Project: PA23-026- Cornelius Lacey PRD – Technical Review 2
Applicant: KM Capital, LLC
Property Addresses: 8310 Sunnyside School Rd and 4427 83rd Ave NE, Marysville, WA 98270
Project Description: 67 Lots – PRD

Regarding: Applicants response to Technical Review Letter for Preliminary Plat,

HORIZONTAL CONTROL PLAN
MARYSVILLE WASHINGTON

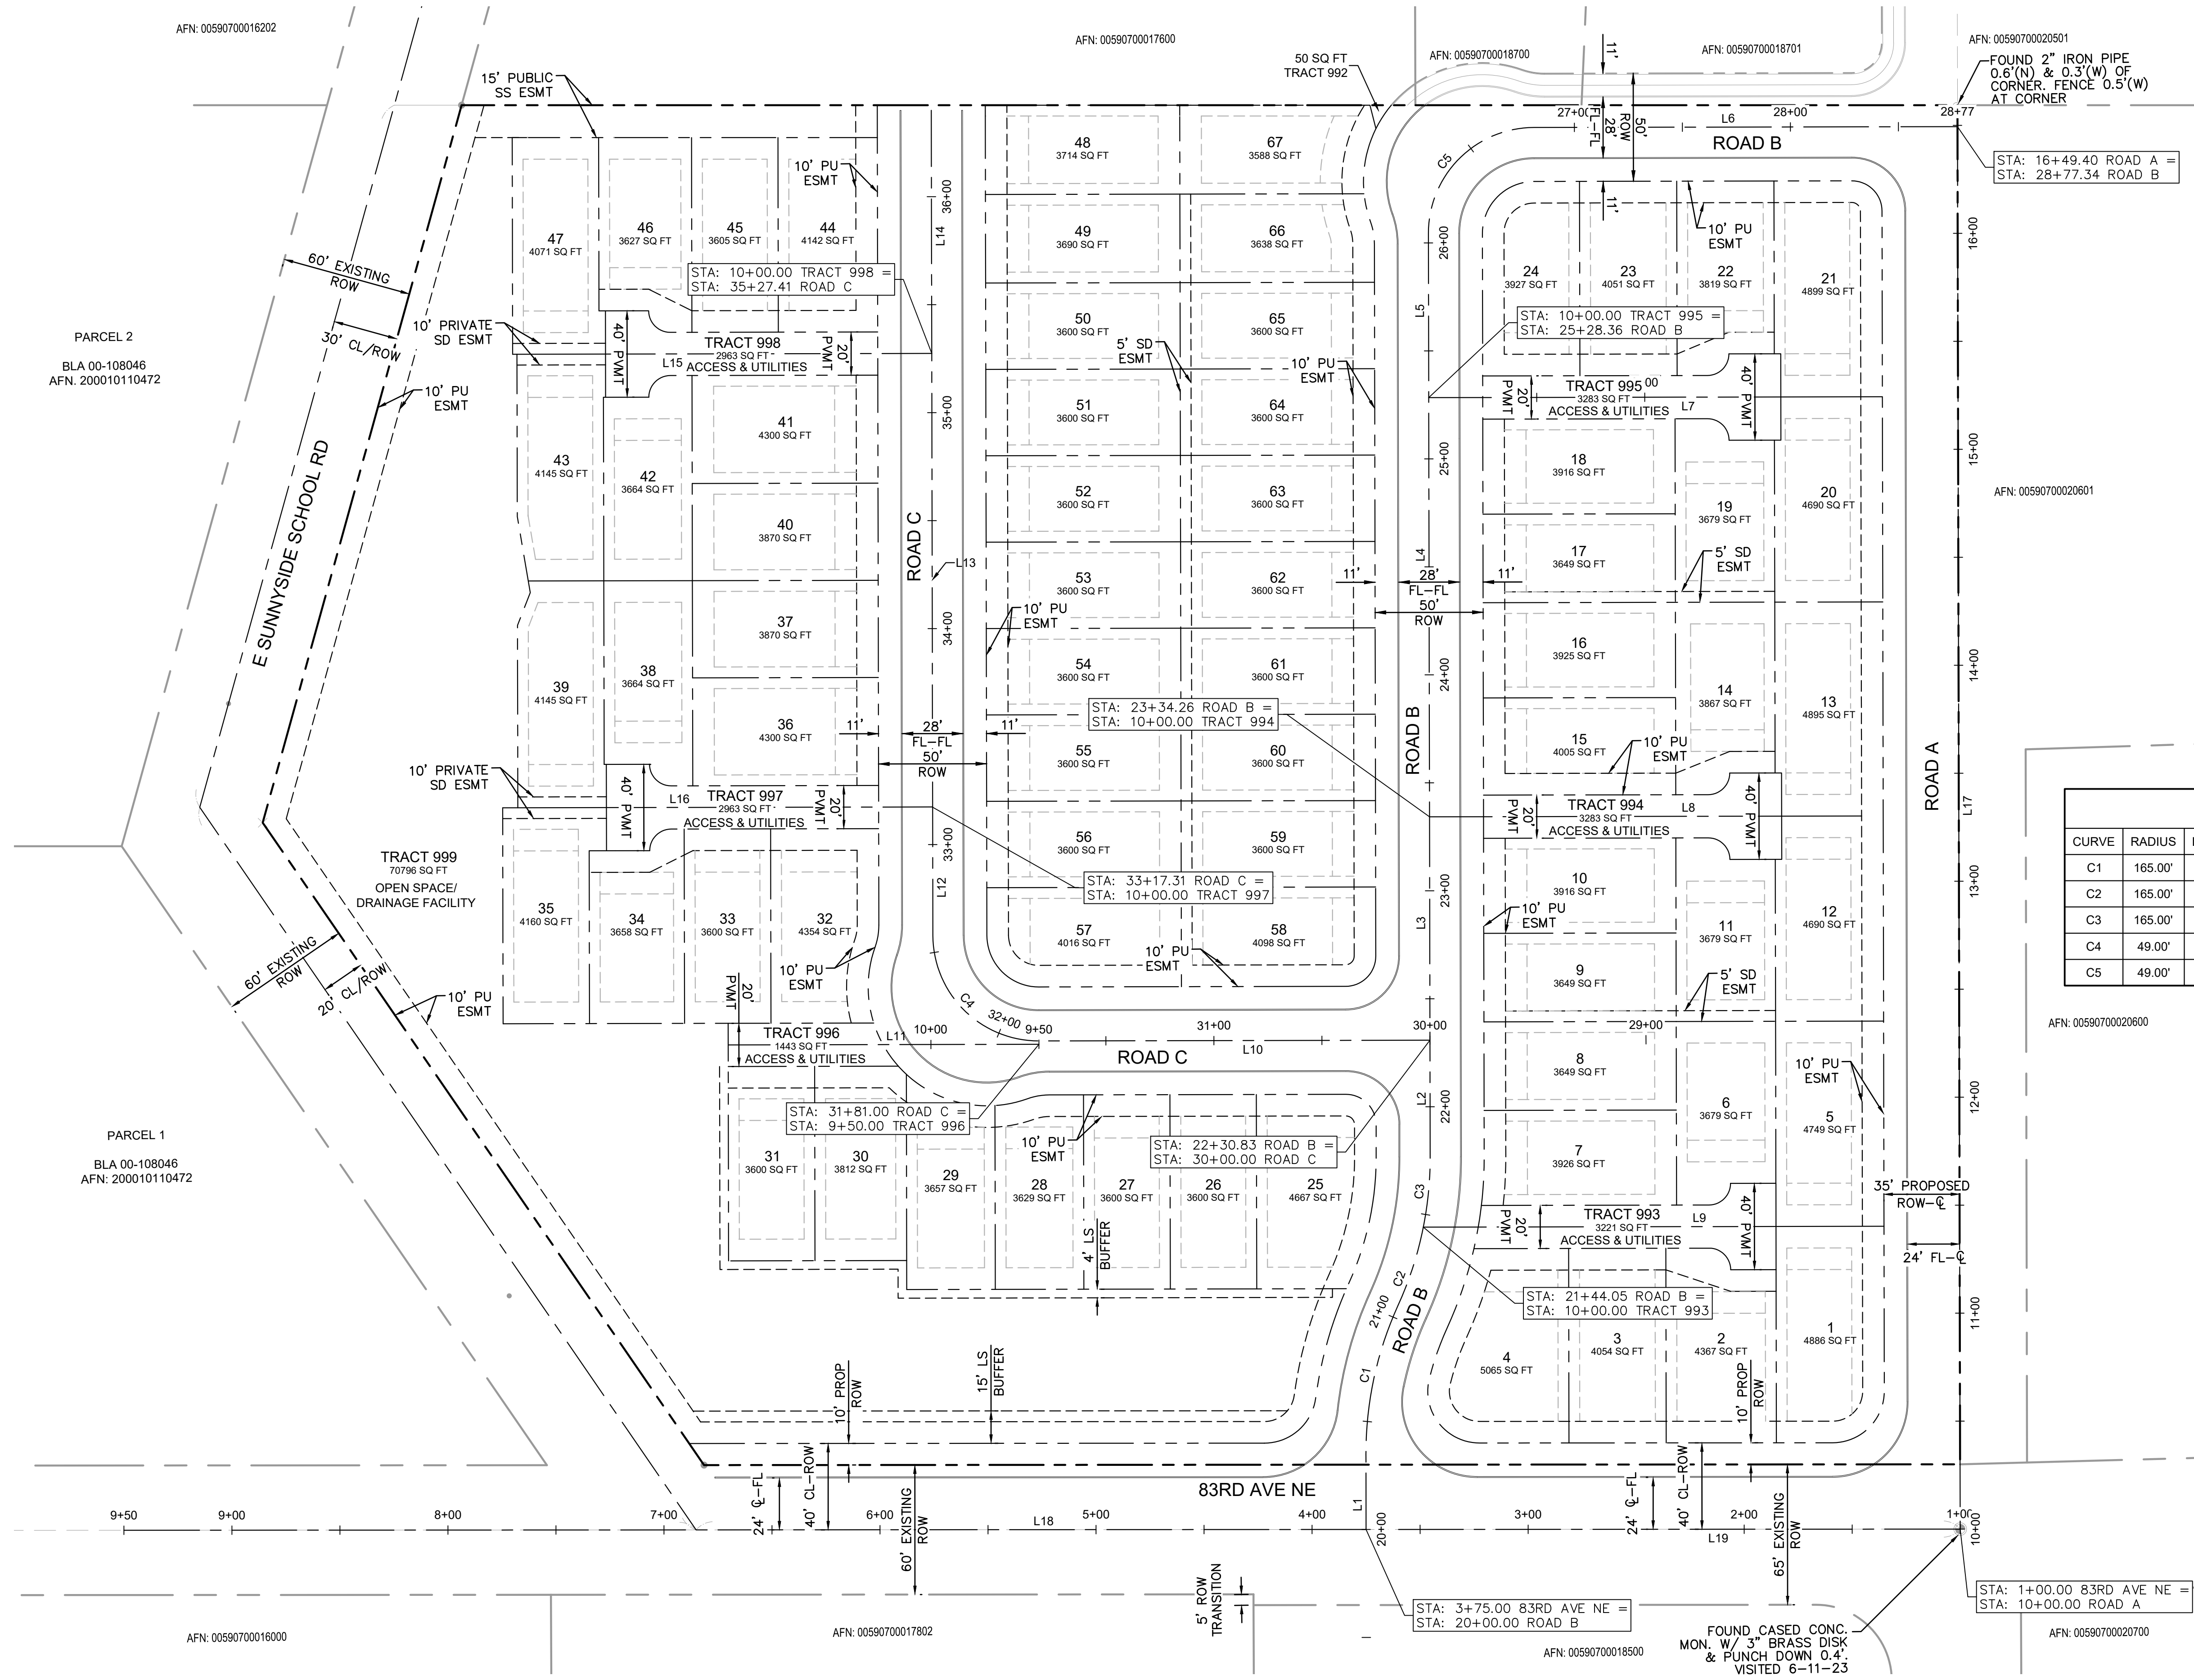
3. Frontage improvements shall be required upon 83rd Ave NE frontage.
 - a. Roadway cross-section shall be 70' ROW three lane roadway with bike lanes per EDDS Standard Plan 3-201-004

- i. Cross-section shall be site specific and identify with dimensions existing and proposed pavement width with channelized lane widths to ensure that roadway will be constructed to standard.

Applicant Response: The project has provided a half road section along the project frontage based on standard plan 3-201-004. The proposed half section would provide 24 feet of roadway (from centerline to face of curb), this is reflected in the section on sheet 2 of 14.

SHEET NO:
L-2
OF 7

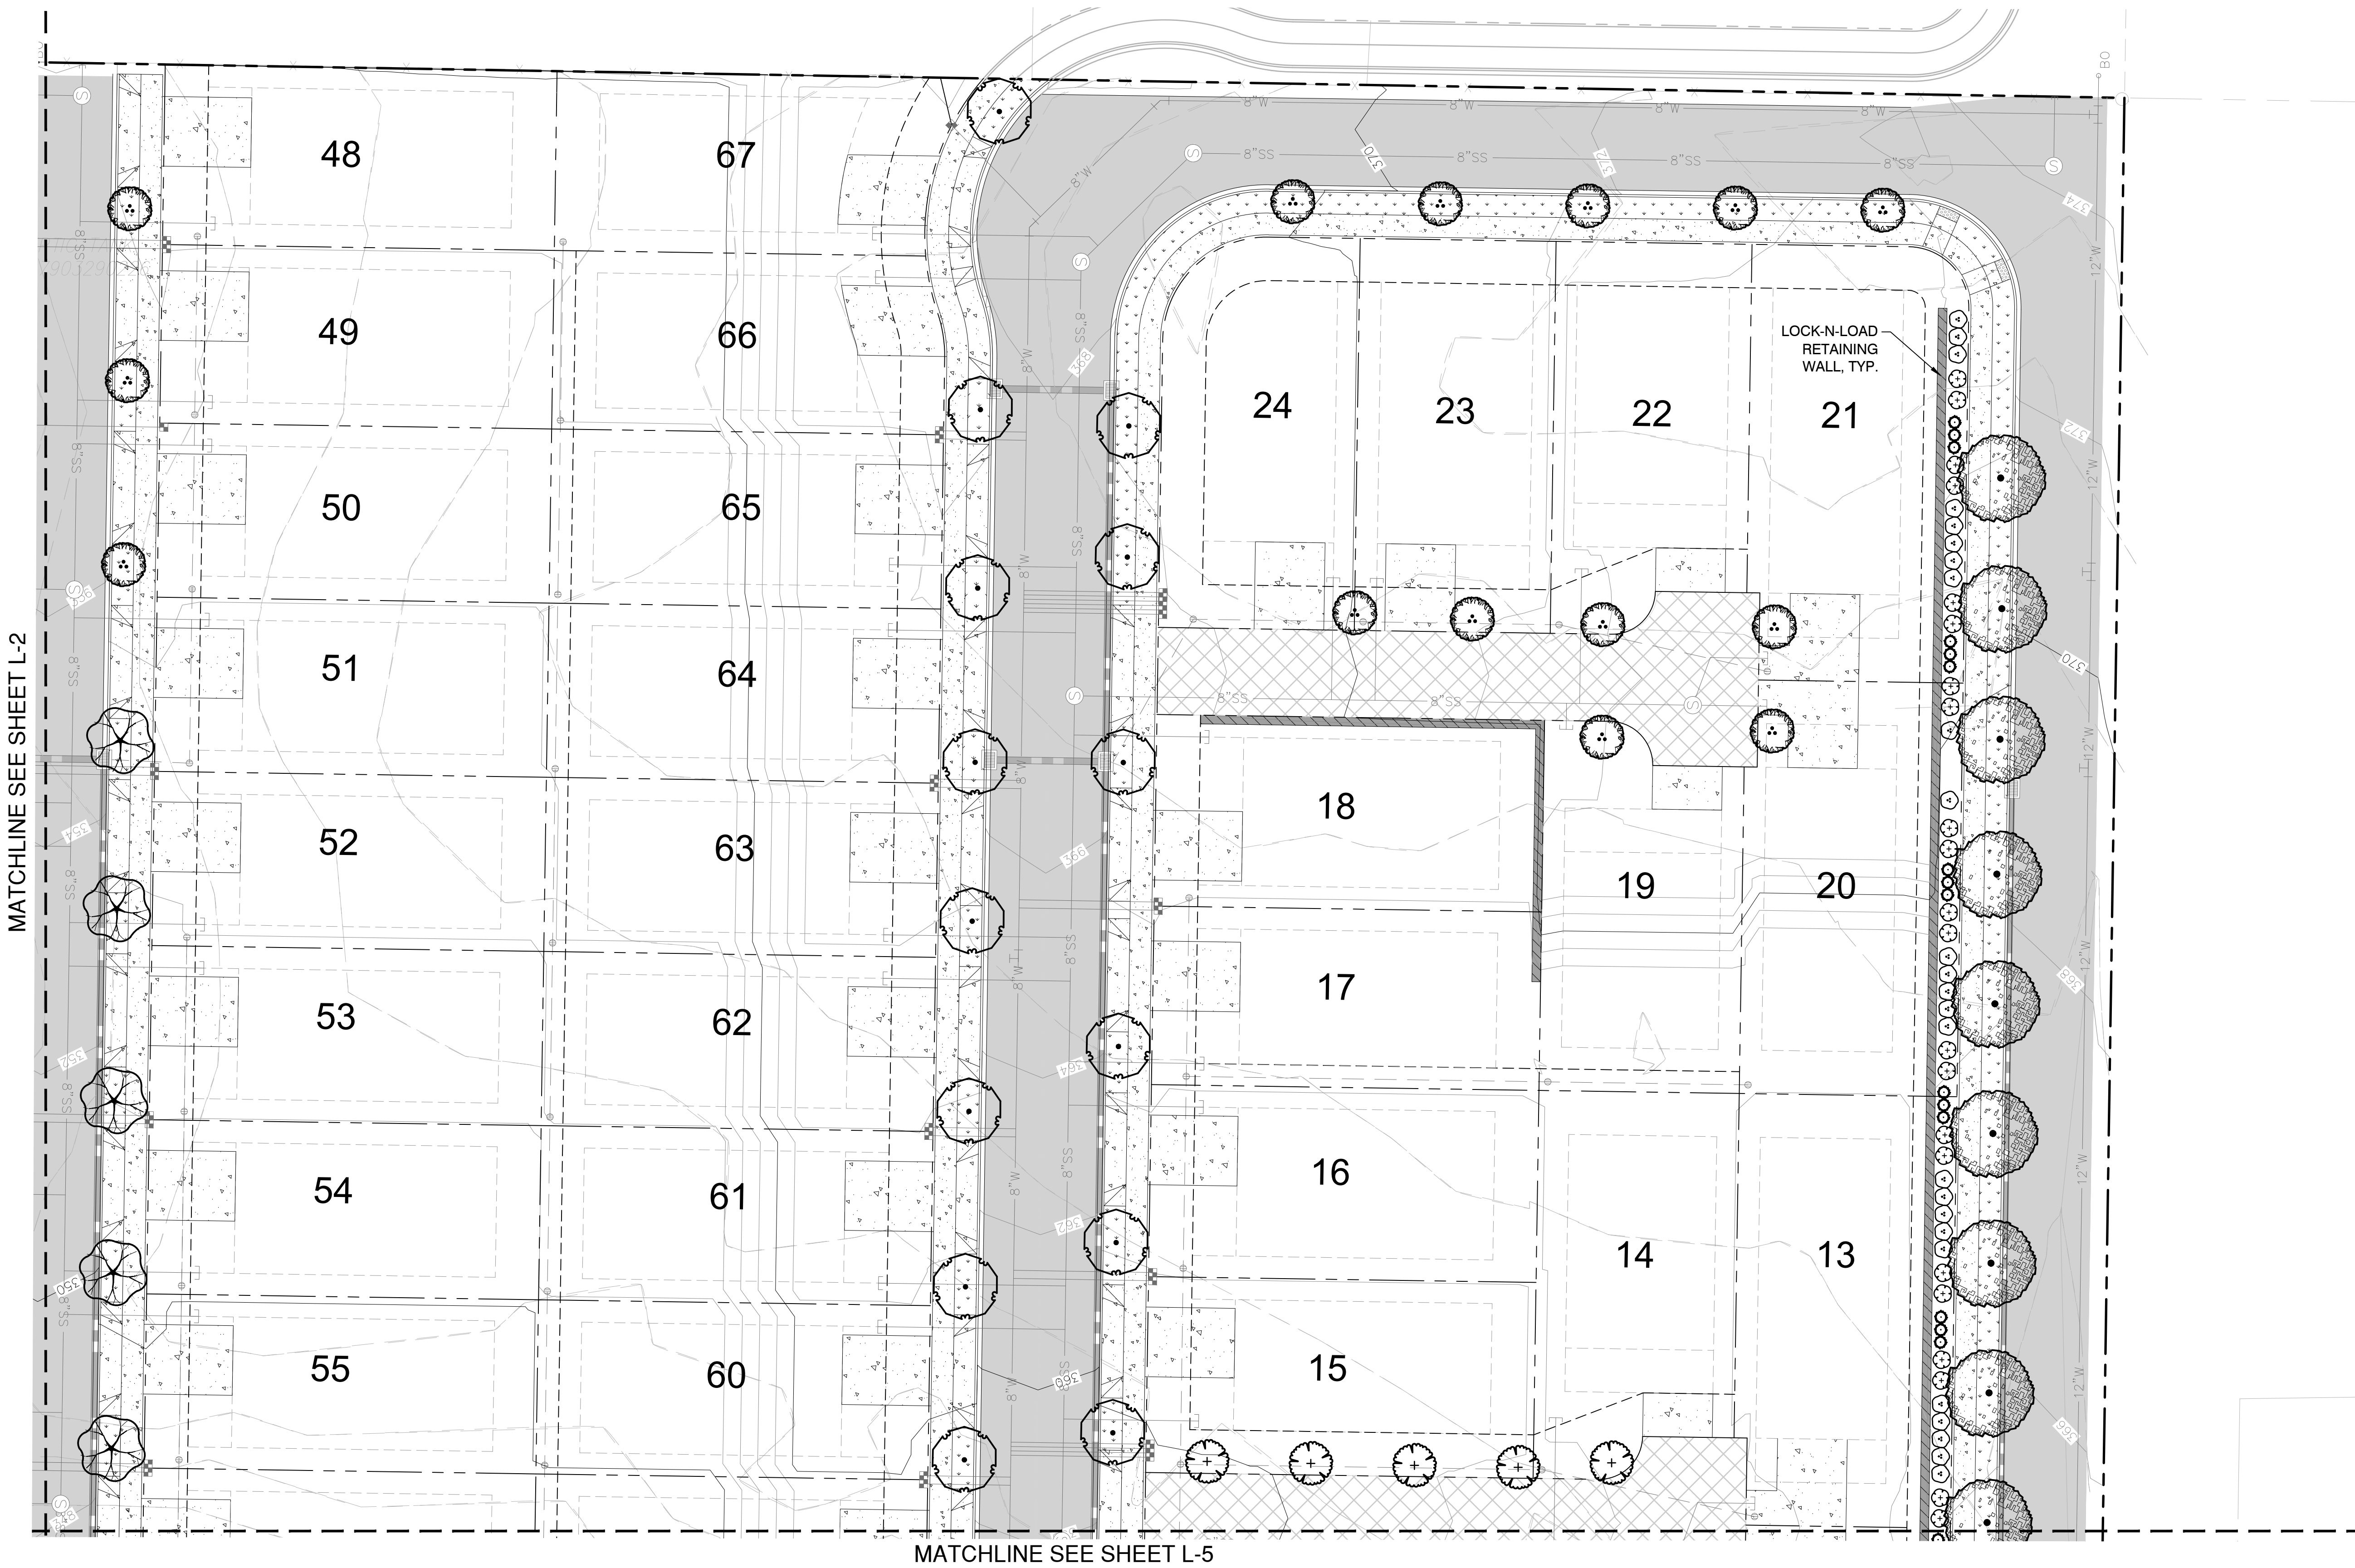
1. Pursuant to [MMC 22D.050.030\(4\)\(e\)](#), if retaining walls taller than four feet are used, and are visible from the street or adjacent property, they shall be terraced so that no individual segment is taller than four feet. Any walls ultimately permitted exceeding 4 feet shall comply with these requirements. Walls on lots 4, 38-43, 18, 10, 57, and 5, as well as some others, have walls exceeding 4 feet. ***These will need to be terraced per the standard below and*** depicted on the plans. The landscape plan does not depict plantings that will screen many of these proposed walls.

Applicant Response: Blank wall landscaping has been provided on Lots 4, 39, a portion of 43, 47, 21 and 20. Walls on other lots are either less than 4 feet or they are not visible from the street or adjacent

property. In many cases the road is higher than the adjacent property and therefore any retaining wall does not need to be screened.

SHEET NO:
L-3
OF 7

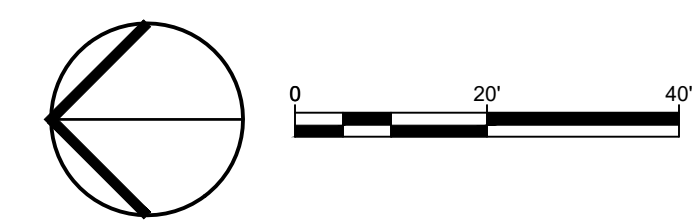
3. In development configurations where side yard abut a street, fences taller than 3-1/3 feet shall be setback as least 5 feet from the sidewalk to allow for landscaping to soften the view of the fence. Provisions for long-term maintenance of this landscaping shall be addressed on the plat.

Additional landscaping is needed along the wall on the southern portion of lot 25.

Applicant Response: Additional landscaping has been provided along the wall on lot 25 adjacent Road B.
